**Southern
Water**

Your ref
BR/255/19/PL

Proposal: Change of use of houses in multiple occupation (Sui Generis) to create 2 No 1 bed, 2 No 2 bed self-contained flats & single storey rear extension to form 2 No studio flats (C3 Dwelling House).

Site: BR/255/19/PL: - 34 & 36 Southdown Road, Bognor Regis, PO21 2JR

Roof plan as Proposed
+ Site Layout

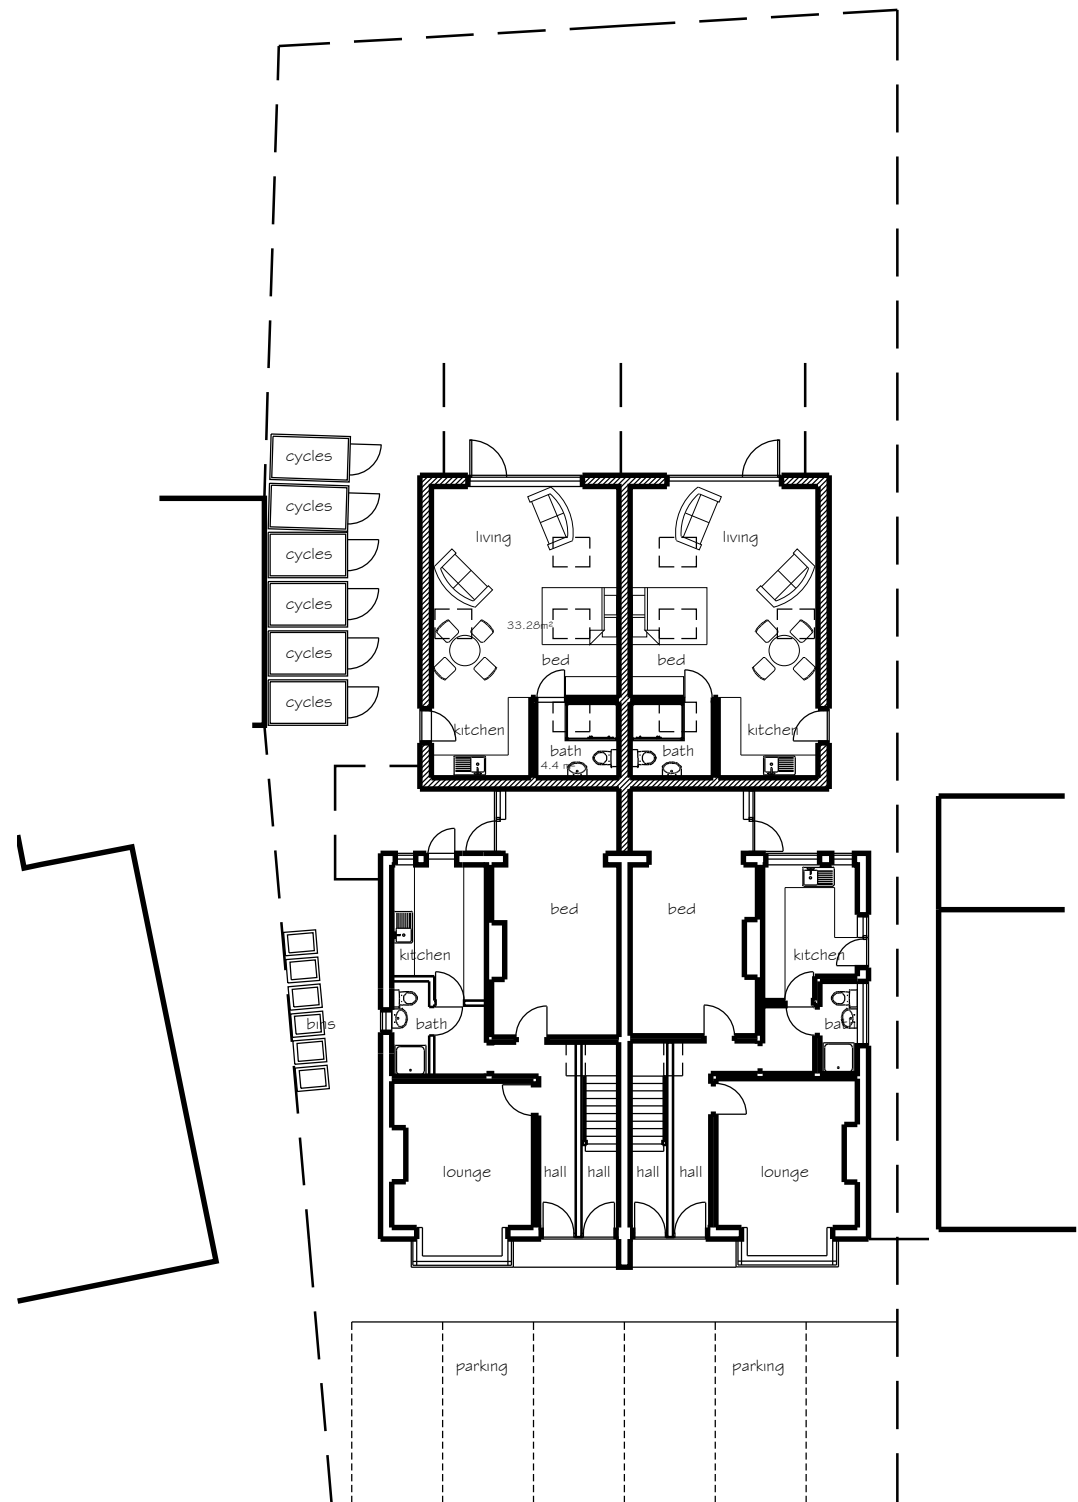
Please find attached a plan of the sewer records showing the approximate position of a public foul sewer crossing the site

It appears that the developer is intending to build close to a public foul sewer which is crossing the site. Building over a "public sewer" is not normally permitted by Southern Water. However, under certain circumstances building close to a sewer may be allowed. The conditions associated with the build over/close to a sewer are contained in Southern Water guidance notes which are available at: www.southernwater.co.uk. A formal application to build close to the sewer will required to be submitted by the applicant.

In order to protect drainage apparatus, Southern Water requests that if consent is granted, a condition is attached to the planning permission for example: "The developer must agree with Southern Water, prior to commencement of the development, the measures to be undertaken to protect the public sewer. "
